SDP V_1 Redlines Planing Only.pdf Markup Summary 10-17-2019

COVER SHEET

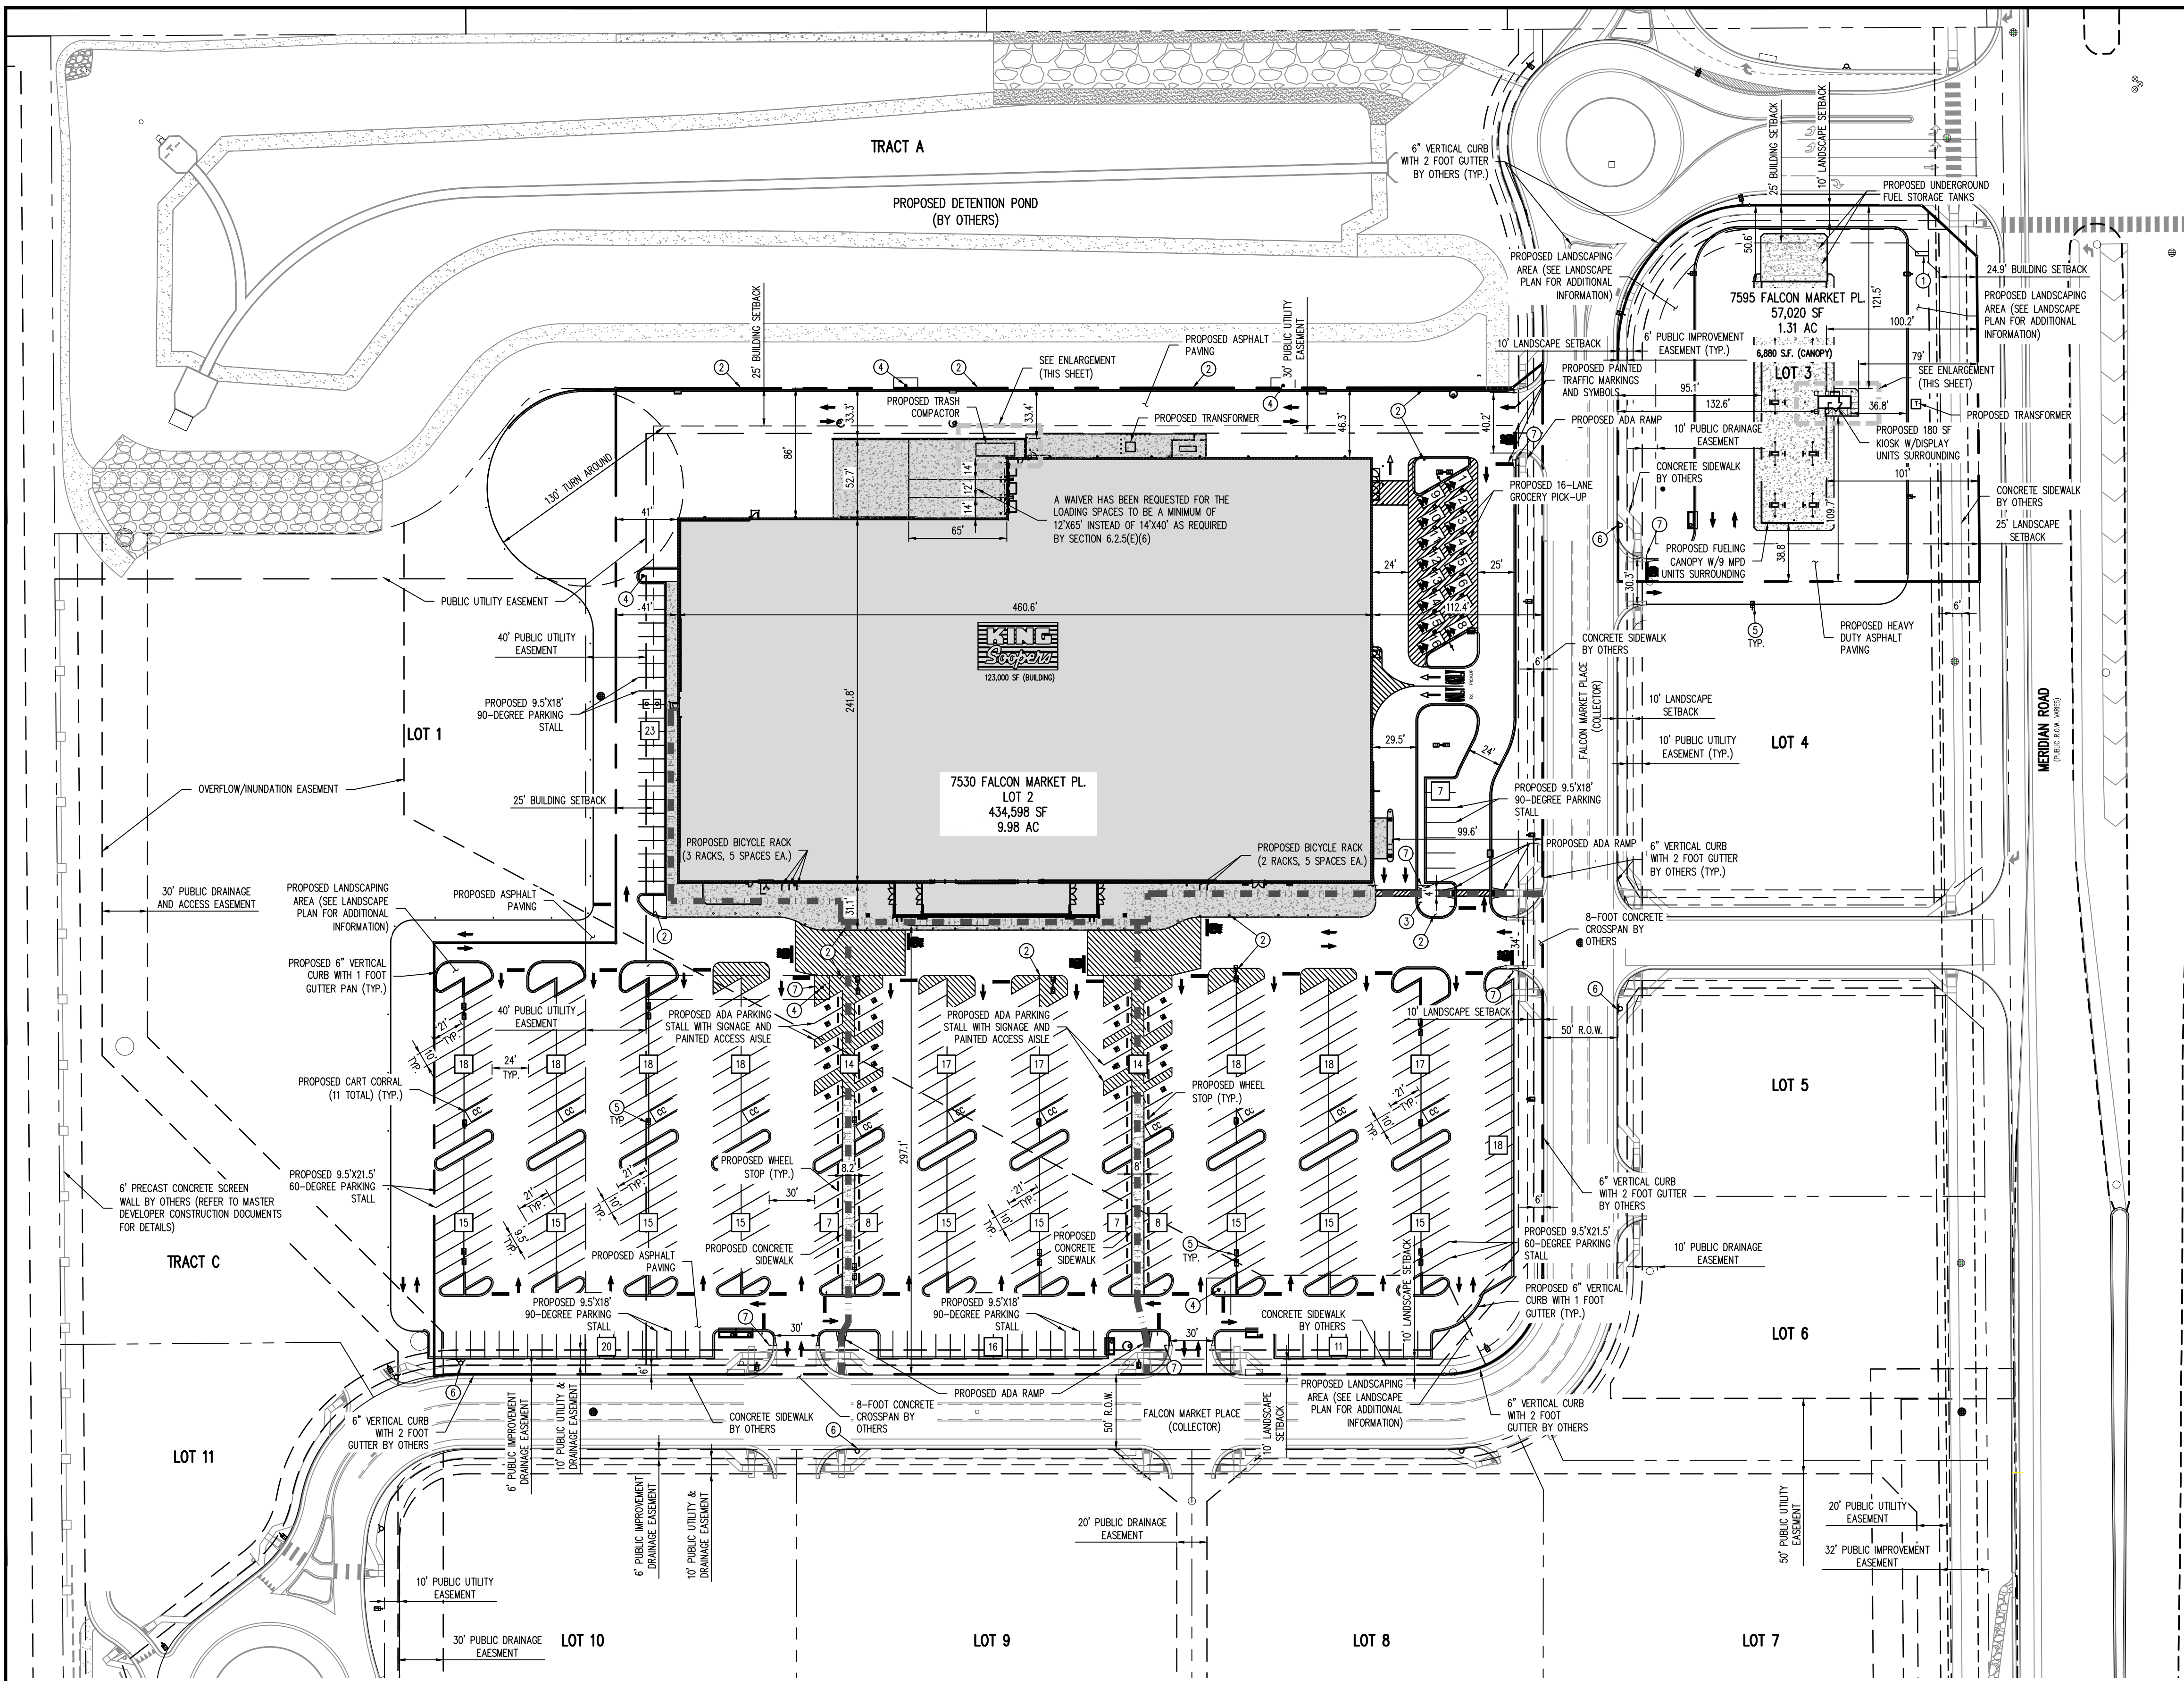
label rack on plan sheet 2

label parking spaces with CC sheet 2 and provide cart corral detail on sheet 3- remove circles with number

sizes?

Legal:- Use future legal after plat recording...

Add zone, all uses,

IF detention / water quality is required for gas Pump facility- provide a note as to who will maintain it. A maintenance agreement will be required.

SITE DETAILS

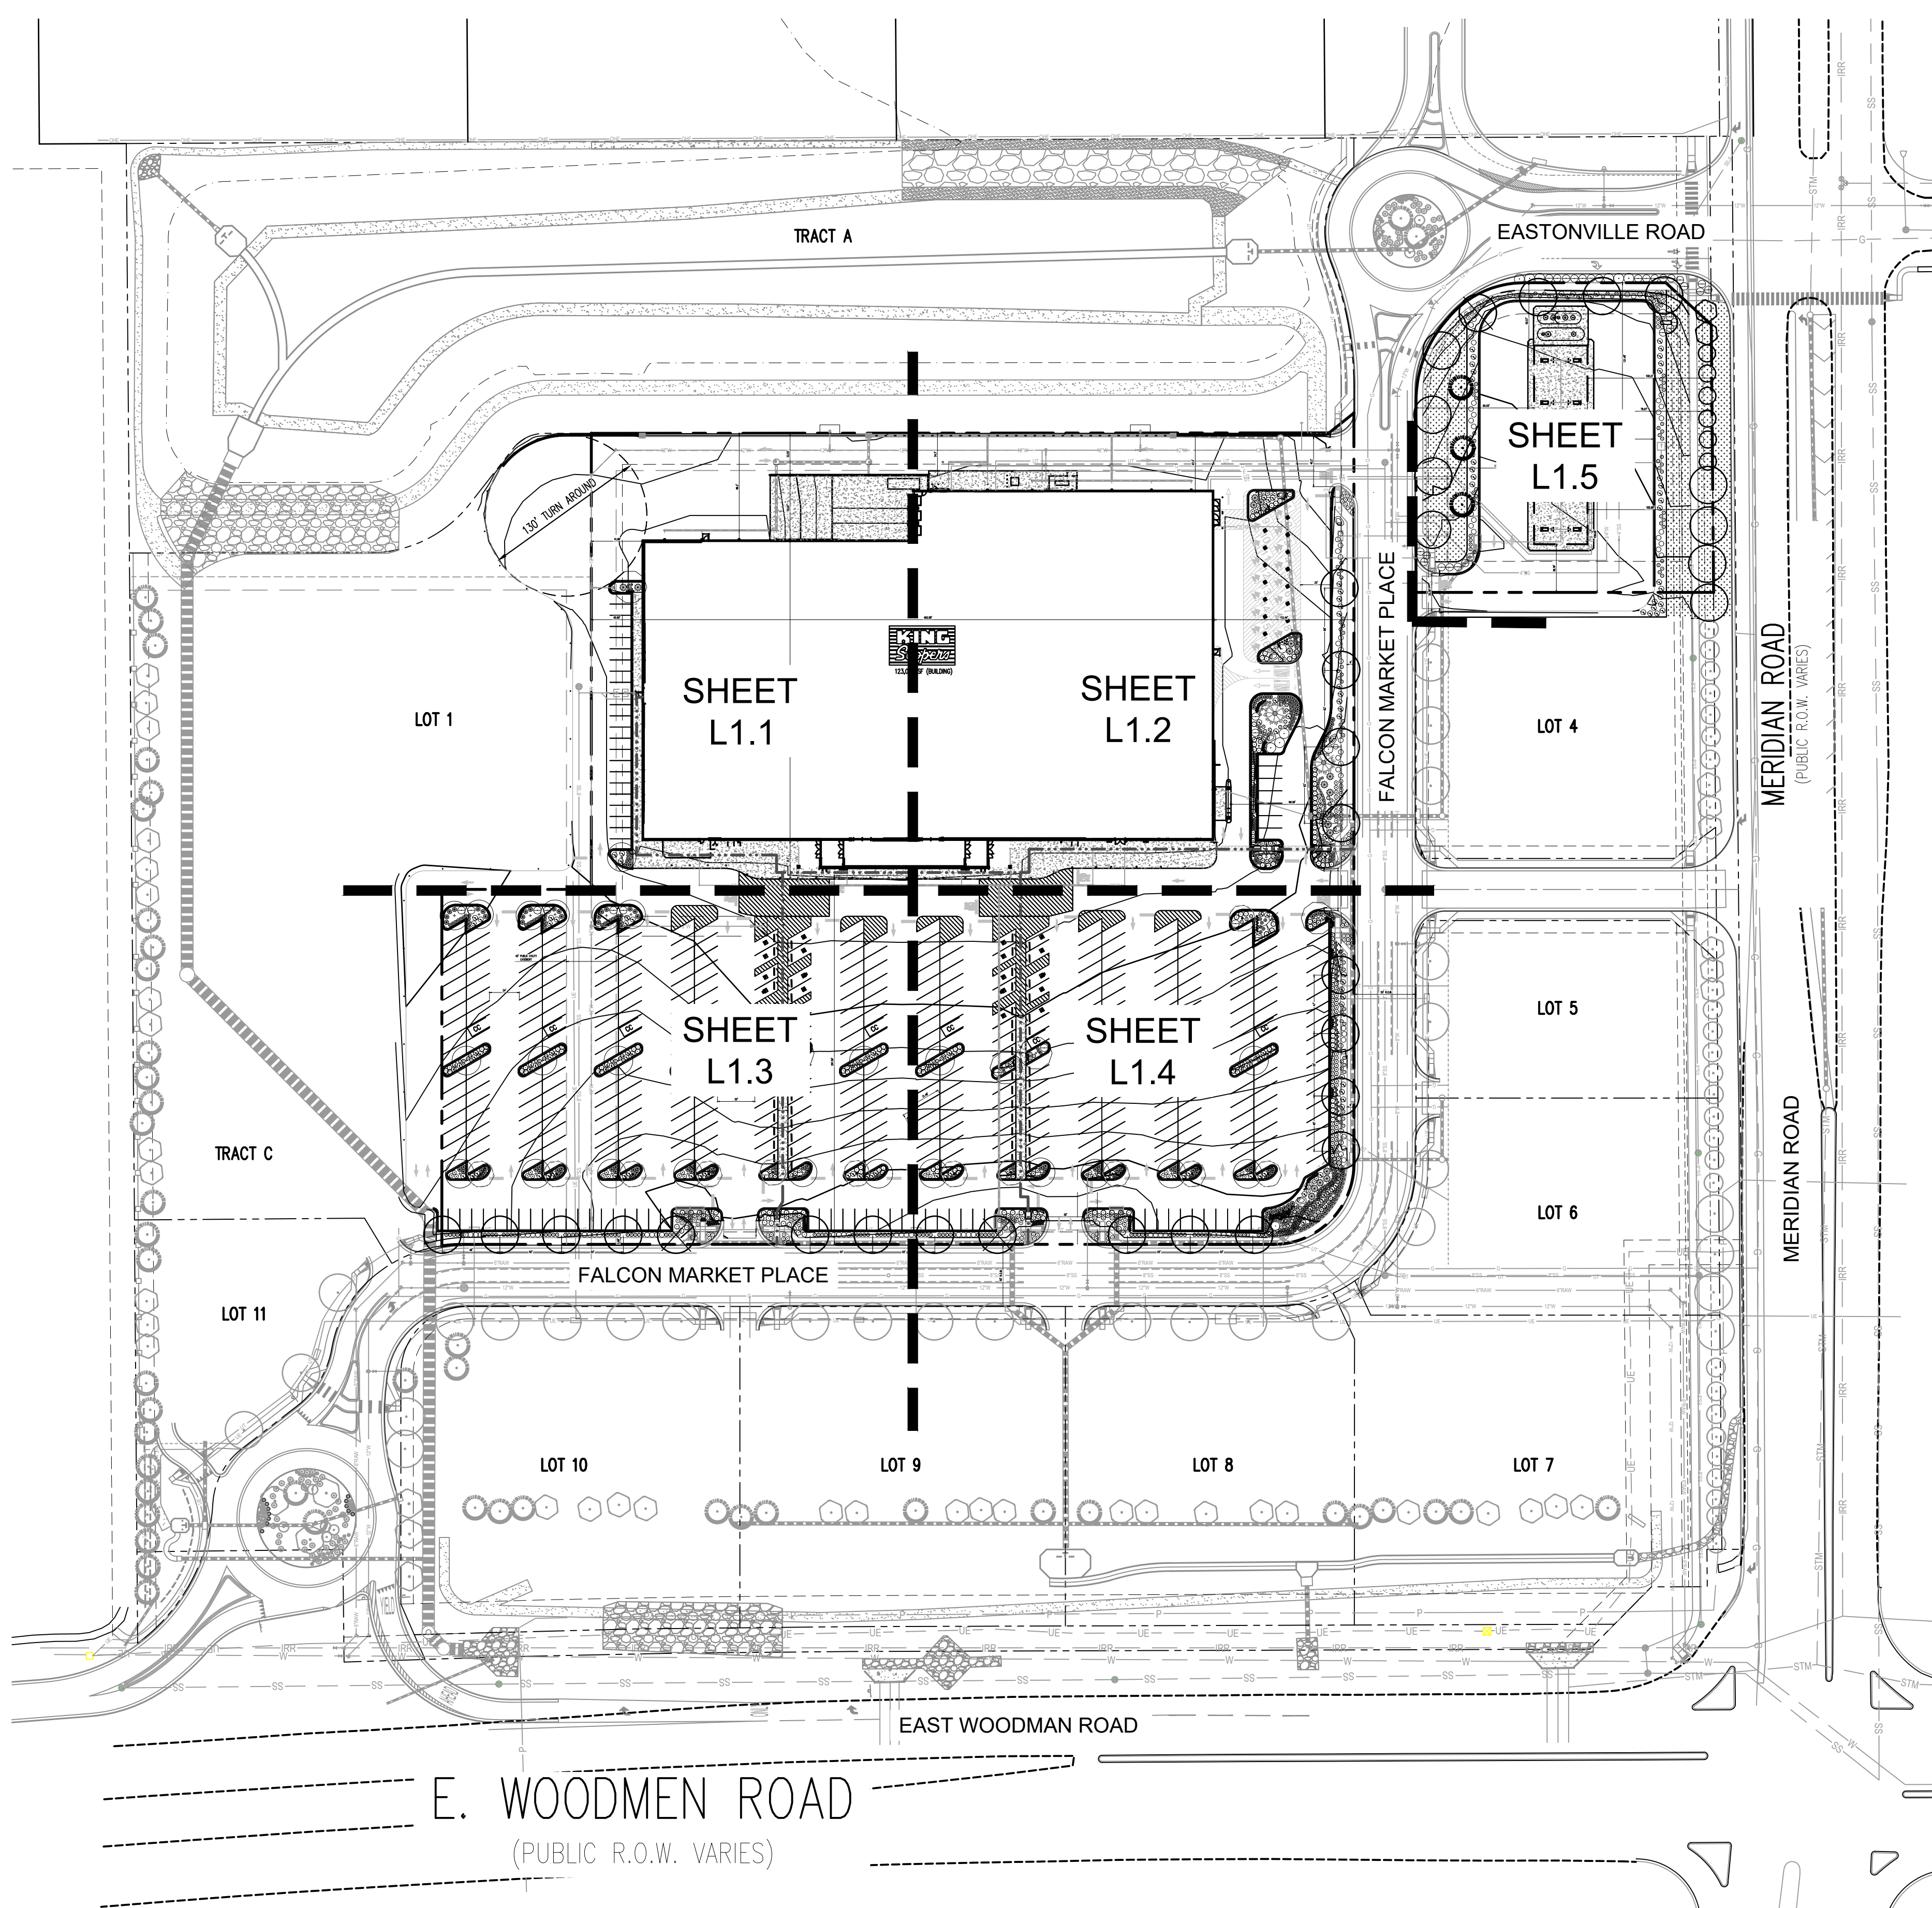
where are sidewalks labels

Dimension ROW

landscape . bldg setbacks setbacks come from property lines not back of curb

you have made the drawing busy and difficult to read; use labels sporadically on drawing itself. We do not need to see symbols repeatedly.

Provide handicap stalls with symbols clearly marked and required ramps.

dimension stall types sporadically- remove circle with number...

provide a parking table with required parking, type, size and amount provided to eliminate busyness from circles with labels

landscape islands required

Delete all yellow circle numbers & provide label on plan sheets

this is an off site light? Why are you putting lights on adjacent properties in the middle of the lots?

put this symbol in each parking spot - remove circle w/ numbers

Appears to be in the 10foot landscape setback from the edge of ROW not curb.- move parking out of landscape setbacks- label all setback lines

building dimensions?

provide building as shown in detail dimension it.

provide all arrows directing traffic for the striping

ghost underground tanks and dimension remove circle w/ numbers-

this is opposite of the floorplans

label all of these lines; distinguish each line type by varying thickness & color gradient throughout all sheets

the property lines are not correct

is this private turn around proposed to be on what will be the County's regional detention tract? I do not think the County will support that-please discuss with engineering. A licensee agreement will be required if supported.

Please provide the lot lines, tract lines with the legal clearly depicted on them.

wall label dimension ? Extend wall north to screen loading areas

Please check with final plat; match the lot lines, easements , ROW. These lines should be very clear and distinct, label lines.

The lot line should be the thickest line.

Existing what?

Proposed what?

label the line, item
etc. do not use
numbered circle...
